Our Ref: EN020028

Date: 18 November 2024

Application by Morgan Offshore Wind Limited and Morecambe Offshore Windfarm Limited for an Order Granting Development Consent for the Morgan and Morecambe Offshore Wind Farms Transmission Assets project

Advice following issue of decision to accept the application for examination

Drawing Number:
BP-GBR-MORG-REG-0183

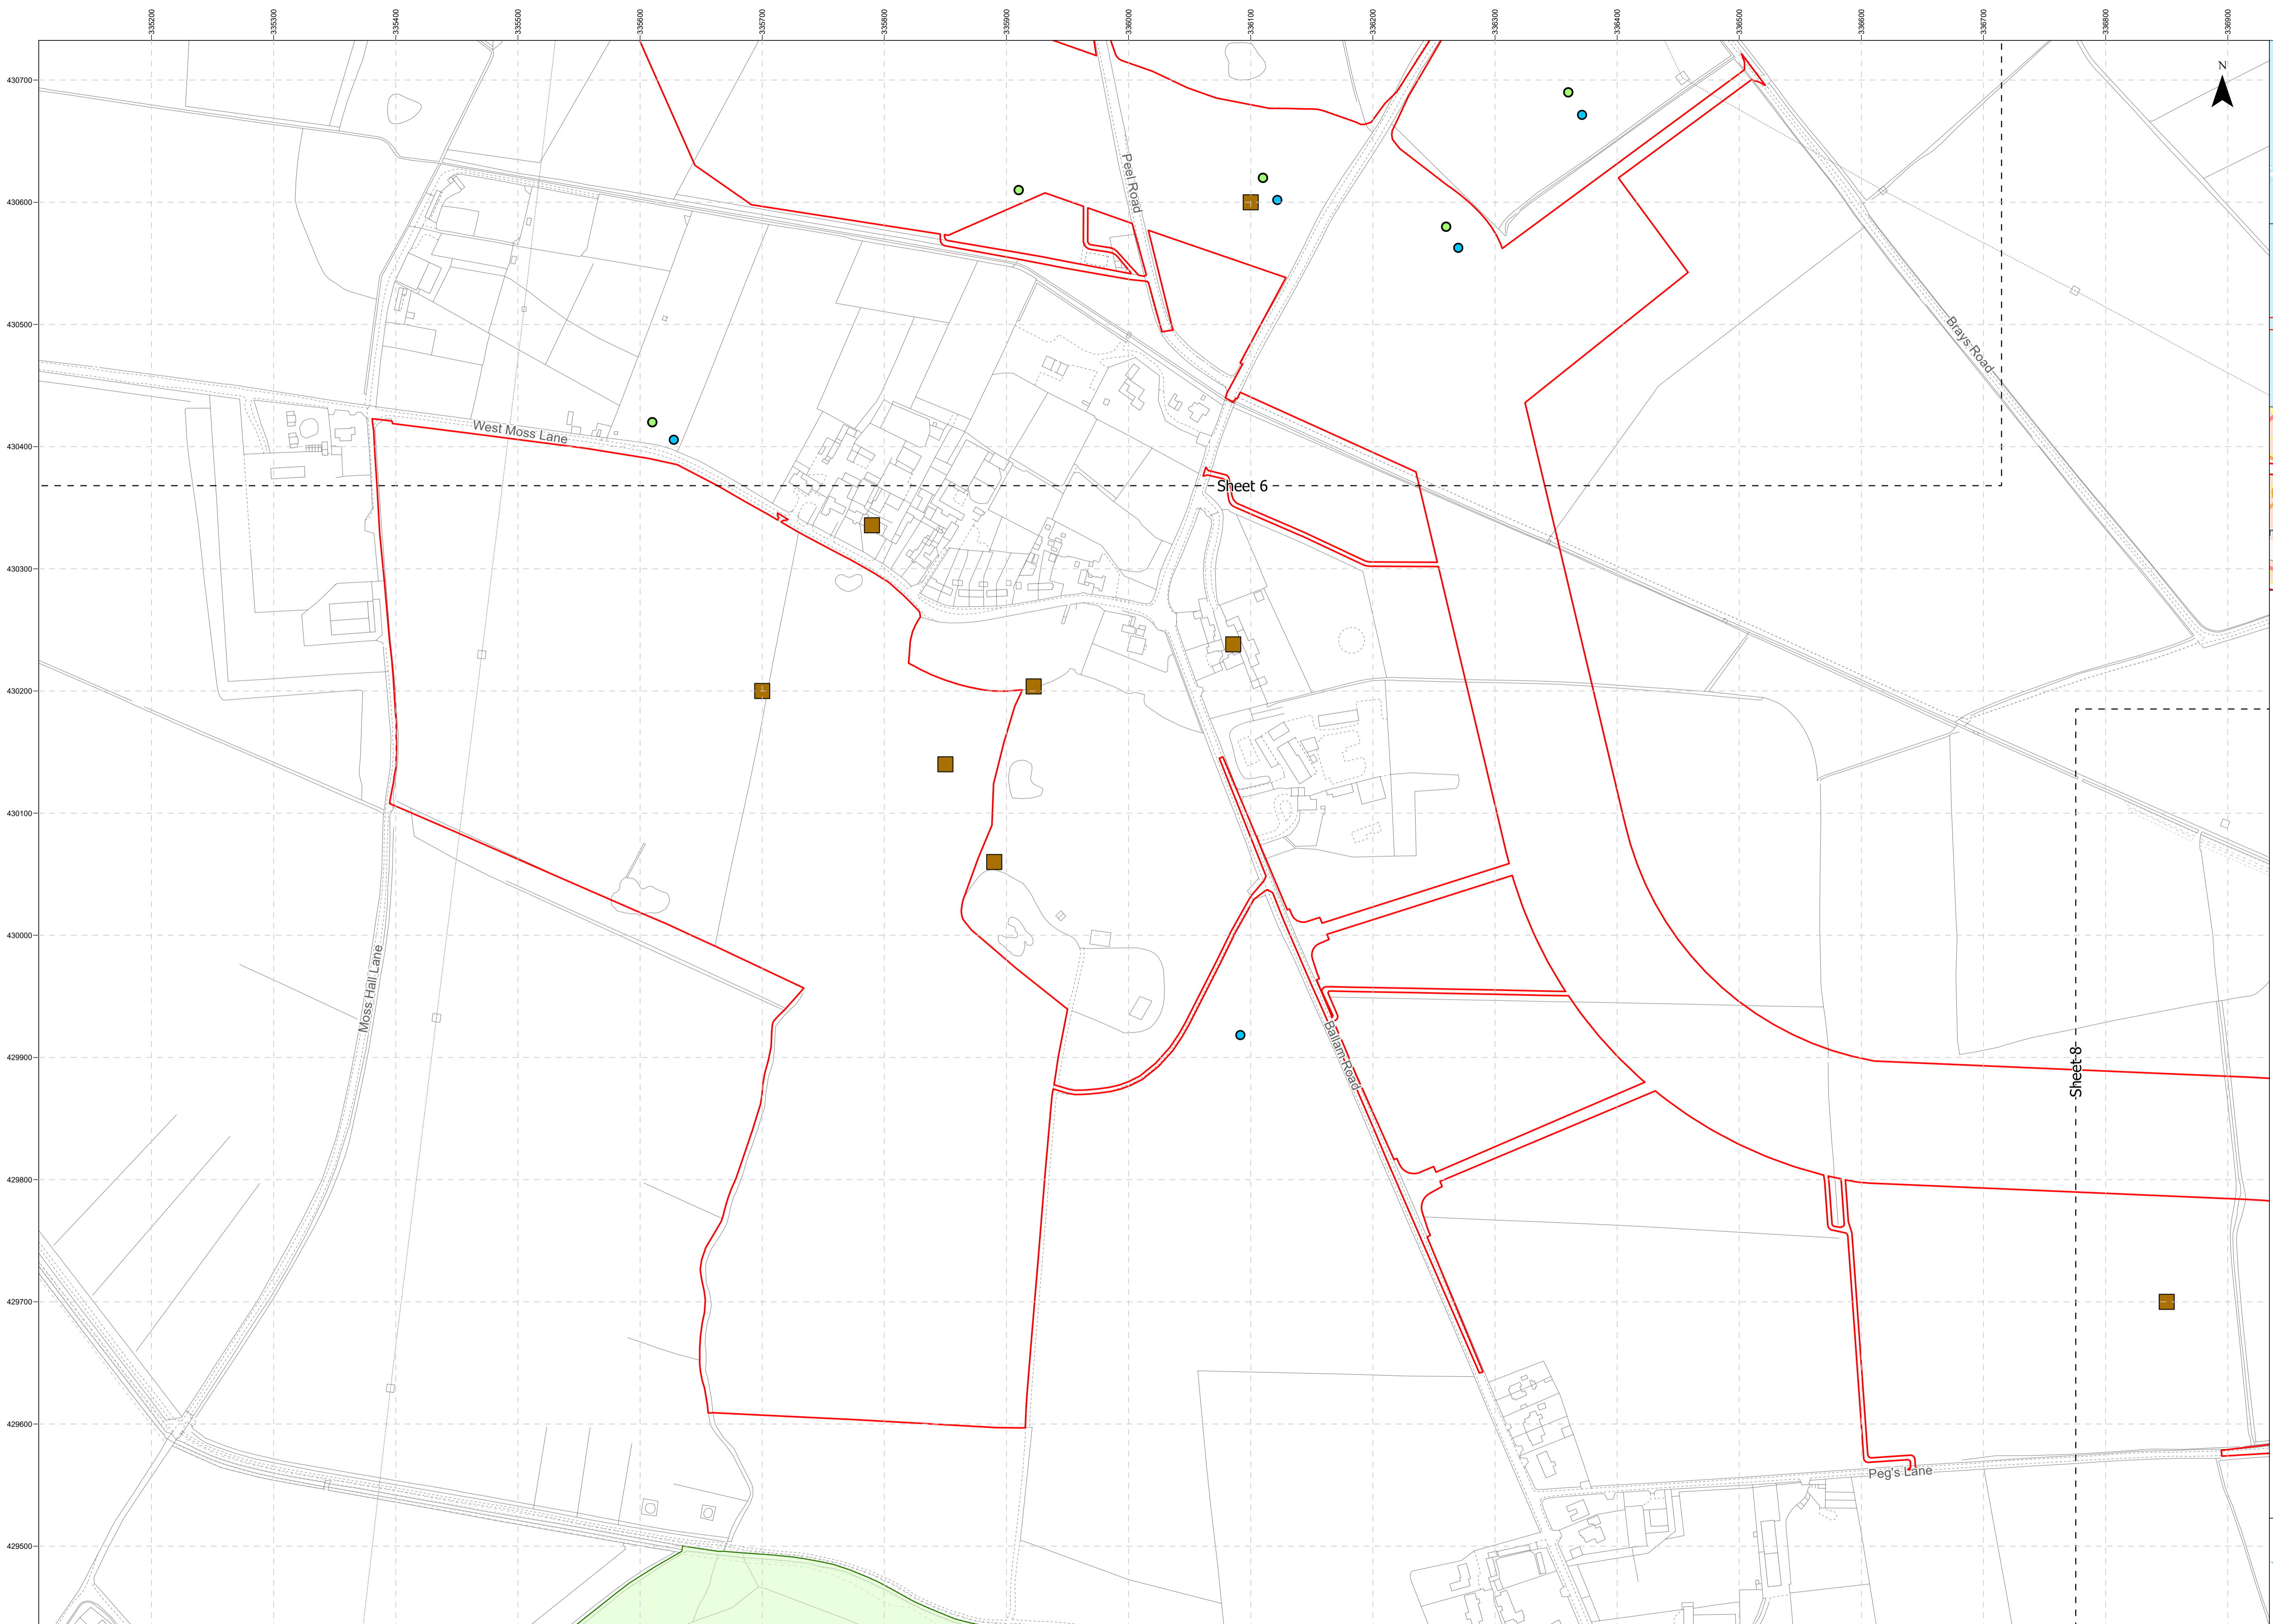
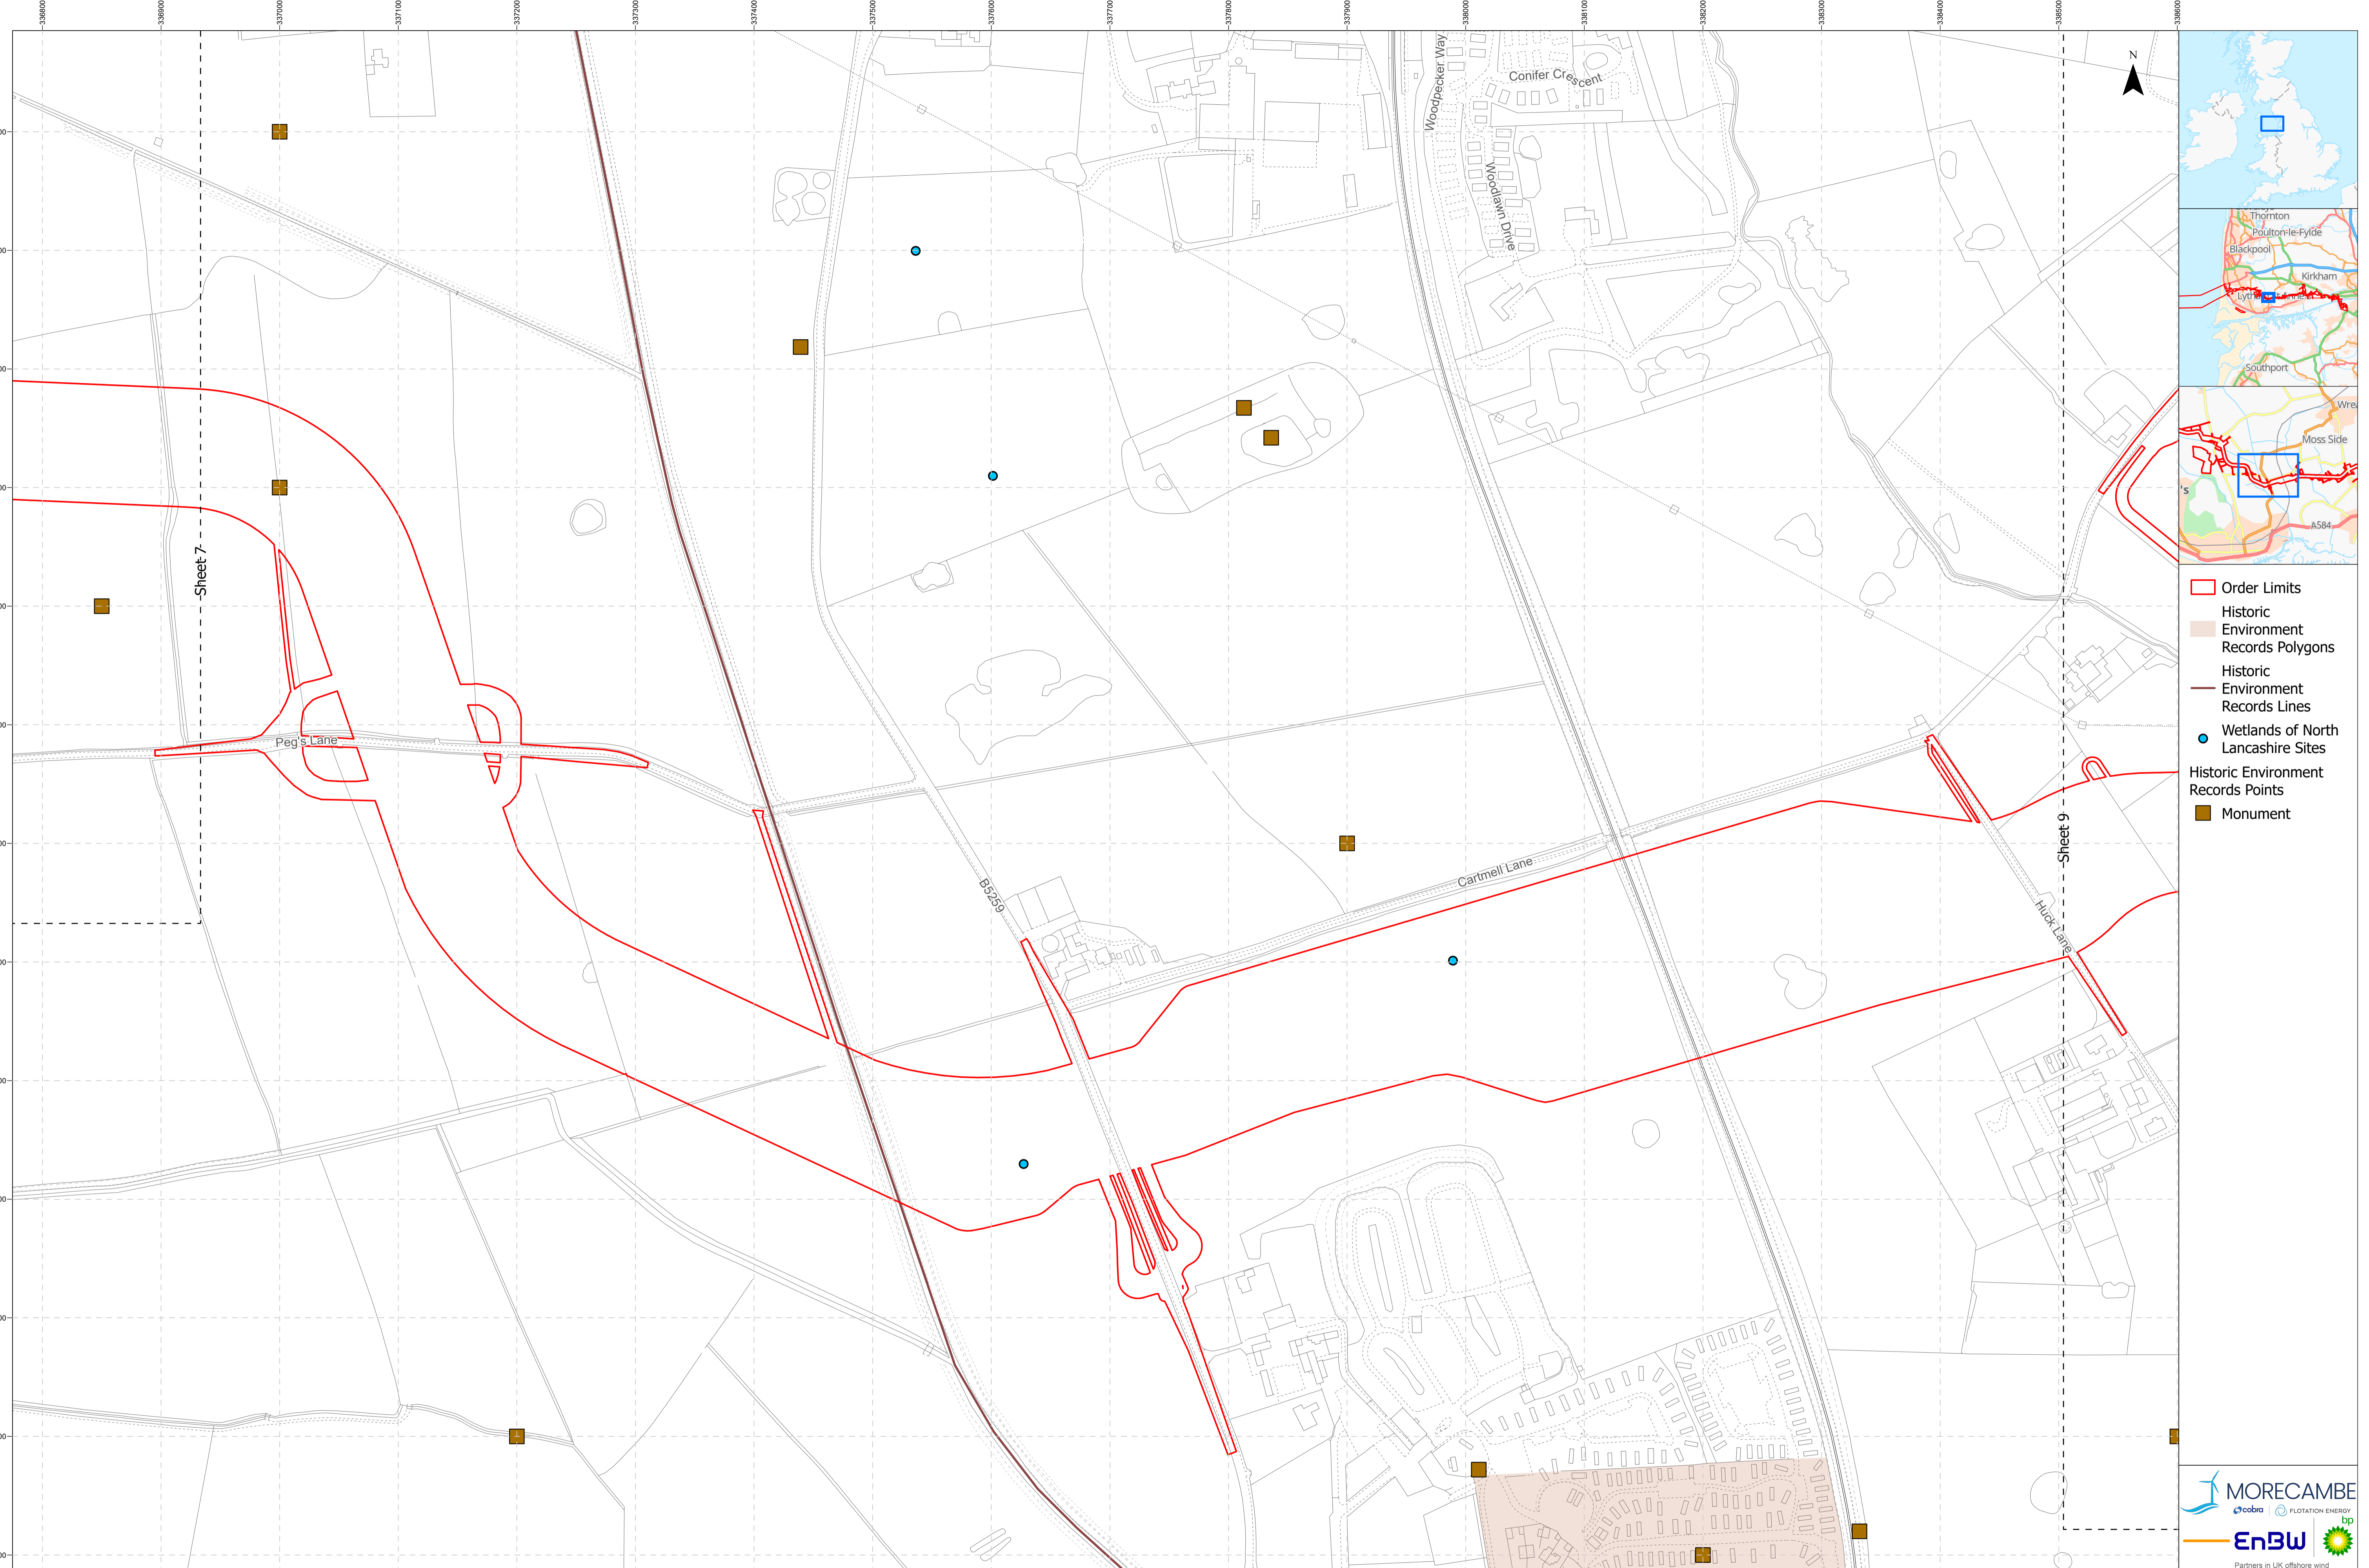
Between the onshore historic or scheduled monument sites (Doc B16) and ES Volume 3 (Doc F3.12, figures for chapter 5), there appear to be some minor differences in terms of the specific assets recorded between these drawings. An example is Doc F3.12 ES figure 5.7 compared to sheet 3 of Doc B16. The Applicants are advised to provide an updated set of figures which are consistent in the features being represented, with appropriate labelling.
